Written Representation at Deadline 1

National Grid Electricity Transmission Project EN020026 : Sea Link

Interested Party: Aldringham-cum-Thorpe Energy Action (ACTEA)

Re: Cable Drum AIL Construction Traffic through Aldringham, Suffolk

Appendix B Suffolk Onshore **Scheme Abnormal Load Routing Plan**

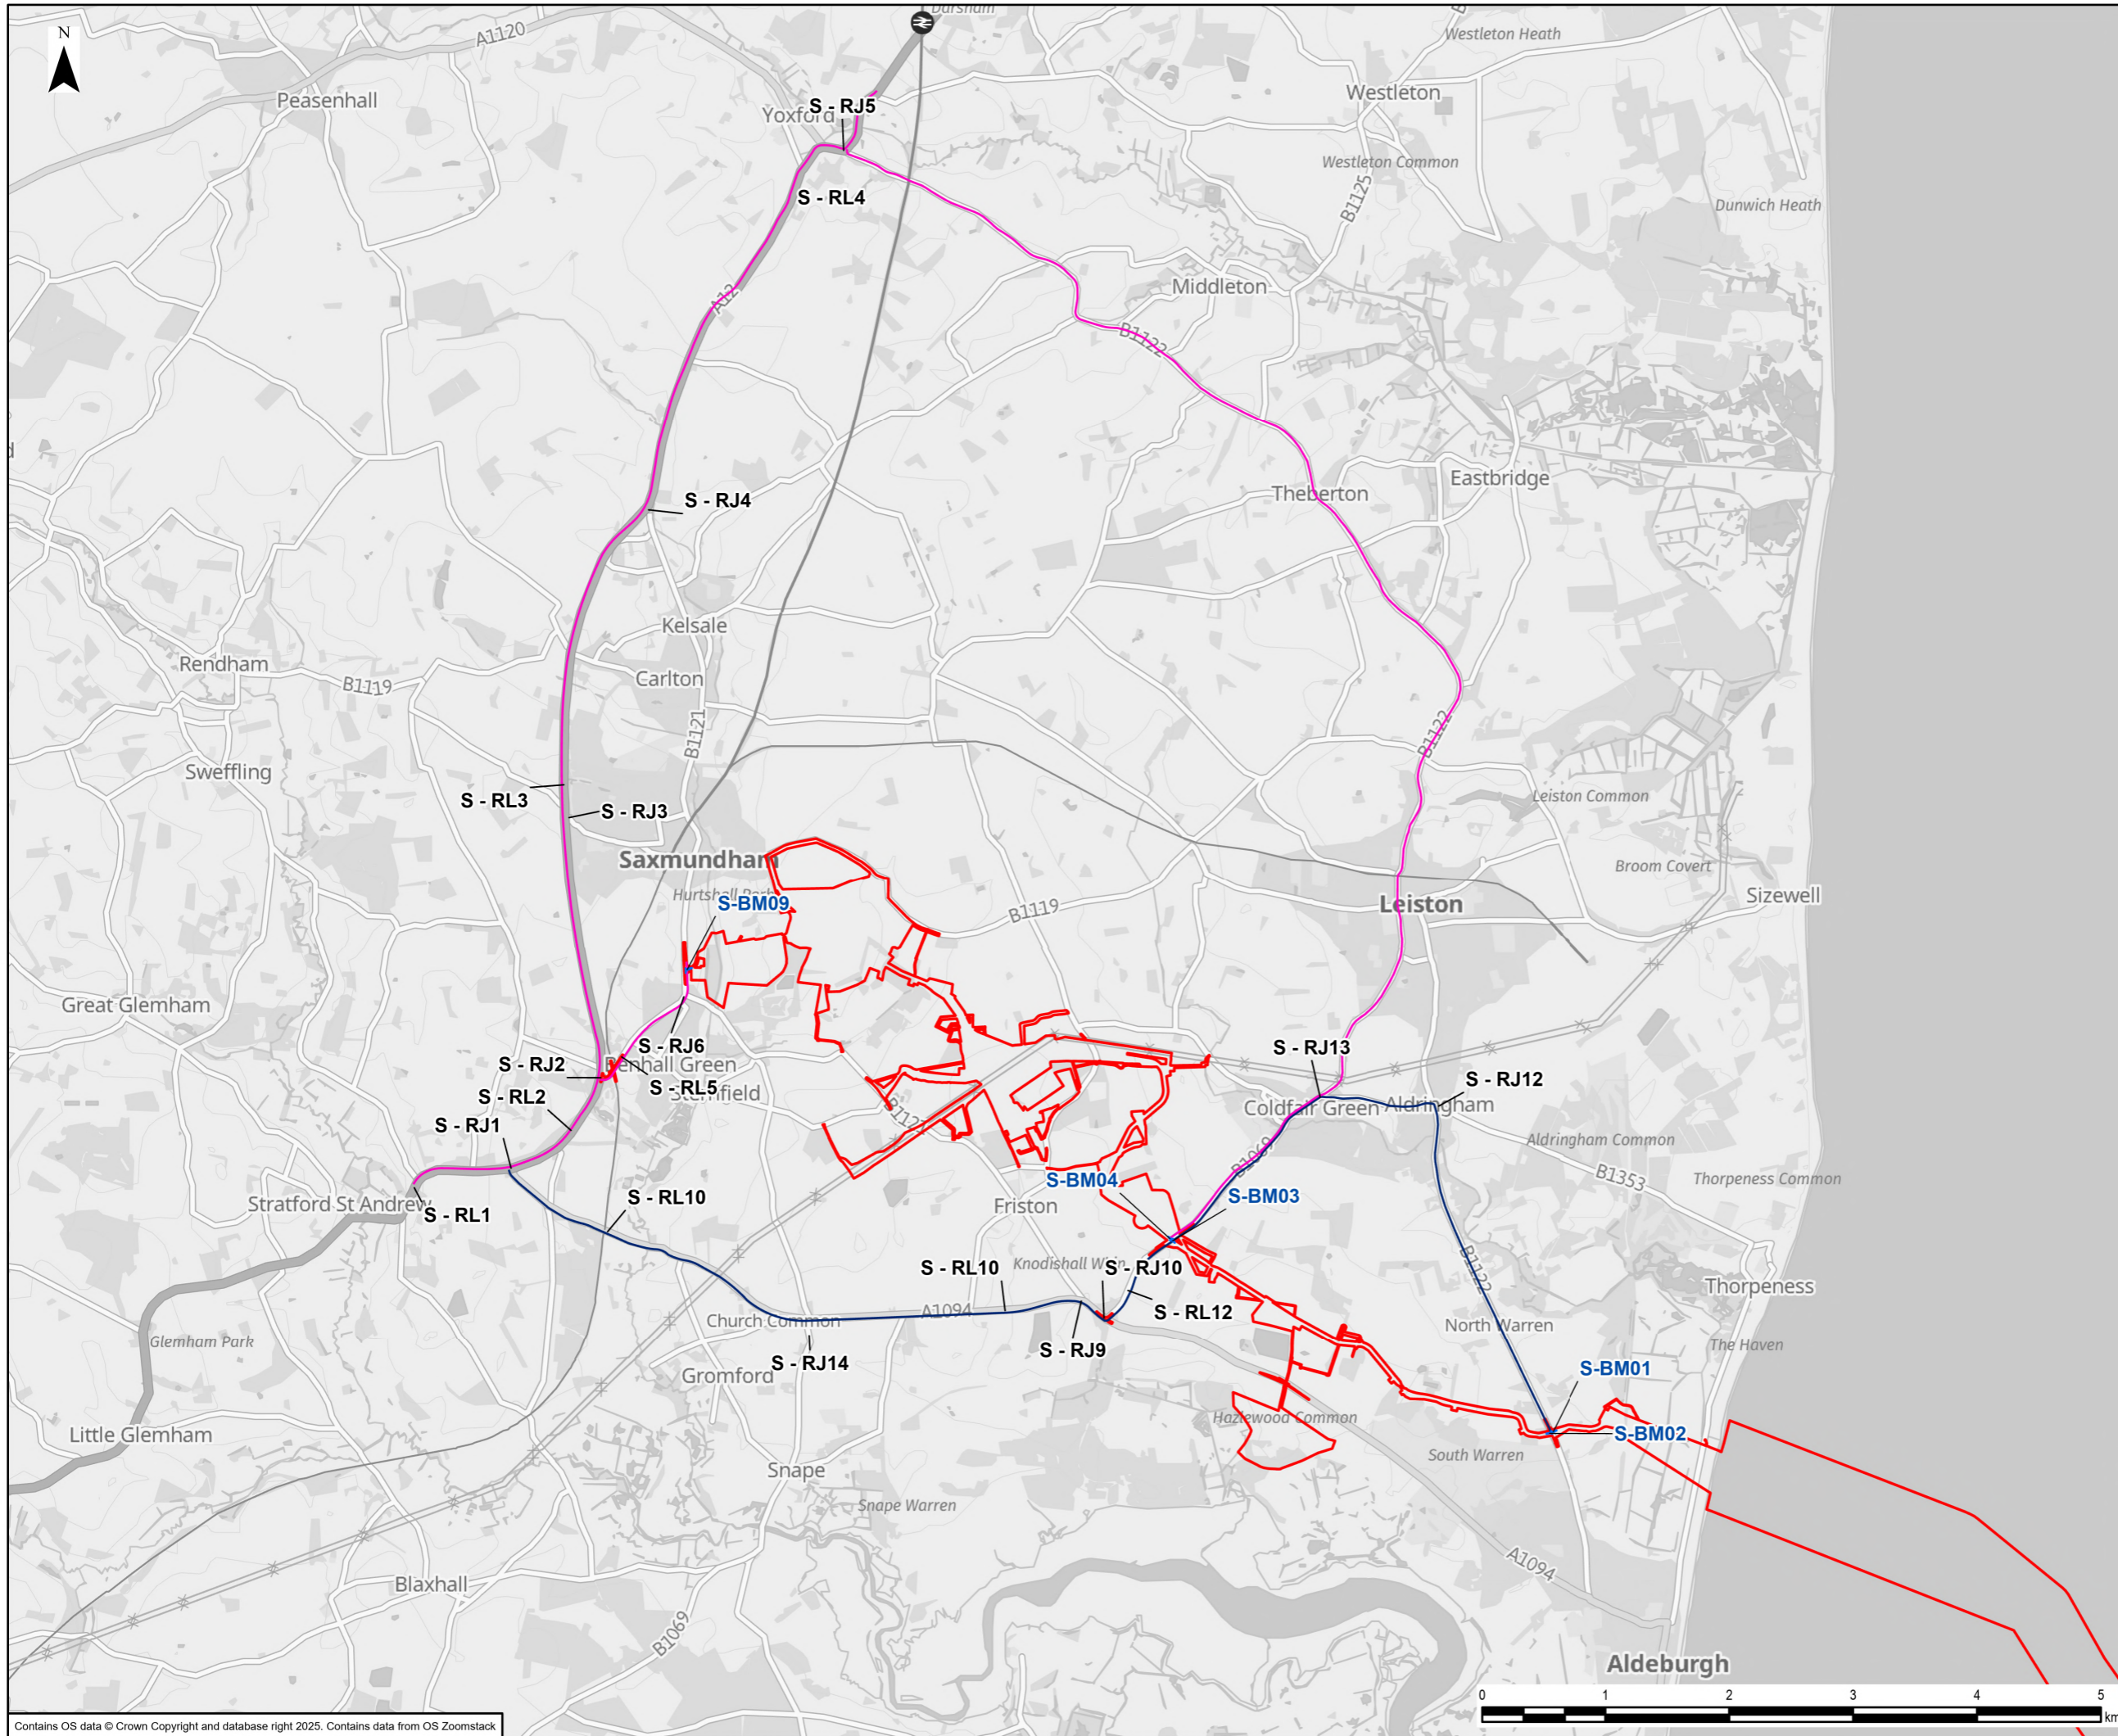
[APP-234](#) 6.4.2.7 Application Document 6.4.2.7 Traffic and Transport – Figures, 6.4.2.7.3 Abnormal Load Routing Plan - Suffolk Onshore Scheme Indicates that the Applicant intends to route Cable Drum Abnormal Loads via B1353 Aldringham Lane between junctions B1069 junction with B1353 (S-RJ13) at Knodishall and B1122 junction (S-RJ12) at Aldringham.

Since the Applicant has acknowledged that the geometry is 'tight' at both junctions AC10 / S-RJ13 and AC11 / S-RJ12, it is disappointing that a design has not been provided to demonstrate how Cable Drum Delivery Vehicles would navigate those junctions.

1. a design specifying those temporary and/or permanent modifications and alterations that would be needed along Aldringham Lane and at its junctions with B1069 and B1122
2. swept path illustrations for AC10 / S-RJ13 and AC11 / S-RJ12 as 'Indicative Bellmouth Access Arrangements' in [APP-037](#) 2.13 Design and Layout Plans, 2.13.1 Design and Layout Plans – Suffolk.
